16 Dec 2014

NSW Government
Department of Planning and Environment

CBD and South East Light Rail Project (SSI 6042) – Comments on Modification No 1

Figure 7-12: Moore Park Precinct Access Plan

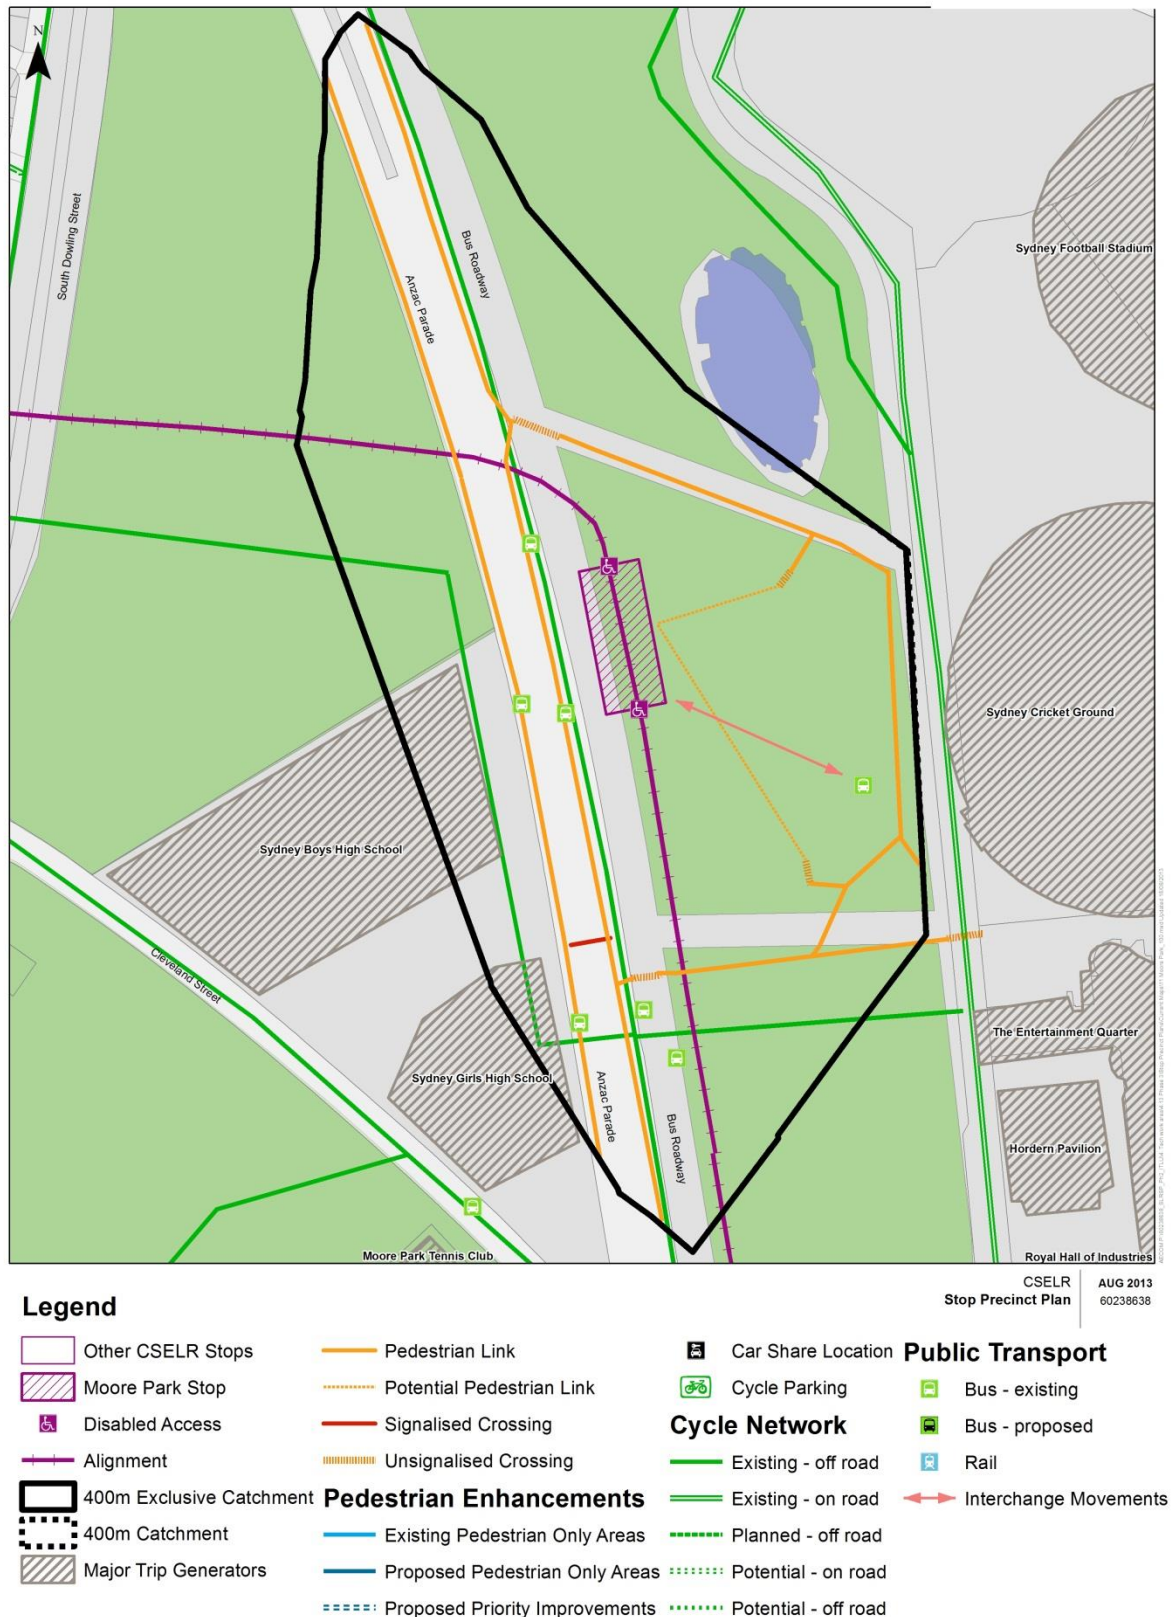
CPMPT had previously registered its concern about the significant visual impact of the stop in the approved design with its elevated concourse and 90 metre long platform. We acknowledge that the removal of the upper level and reduction in platform length in the proposed modification will reduce the height and volume of the structure and its overall visual envelope. However, the beneficial visual impacts of these improvements are offset to some extent by the addition of the stairs and ramps on the eastern side of Anzac Parade associated with the bridge connecting with the high school and the inclusion of what appears to be an amenities block for tram operators at the southern end of the stop (which whilst not specified in the Modification Report, we have been advised is proposed).

CPMPT requests that the visual impact of the stop on the surrounding parkland be further reduced by:

- ensuring the detailed design minimises the visual 'presence' of the proposed stairs and ramps; and,
- deleting the proposed driver / operator amenities block above ground and instead, locating it underground as part of the subways or relocating it to an alternative site.

CPMPT agrees that the proposed pedestrian subways provide a safer arrangement for access to the light rail platform. It is noted, however, that they will only be operational during event mode and will be closed at all other times. CPMPT is concerned that for the majority of time when they are not in use by the general public, the stairs leading down could become a haven for graffiti and other anti-social behavior, and a potential refuge for the homeless. Security monitoring of this area should be considered in the detailed design.
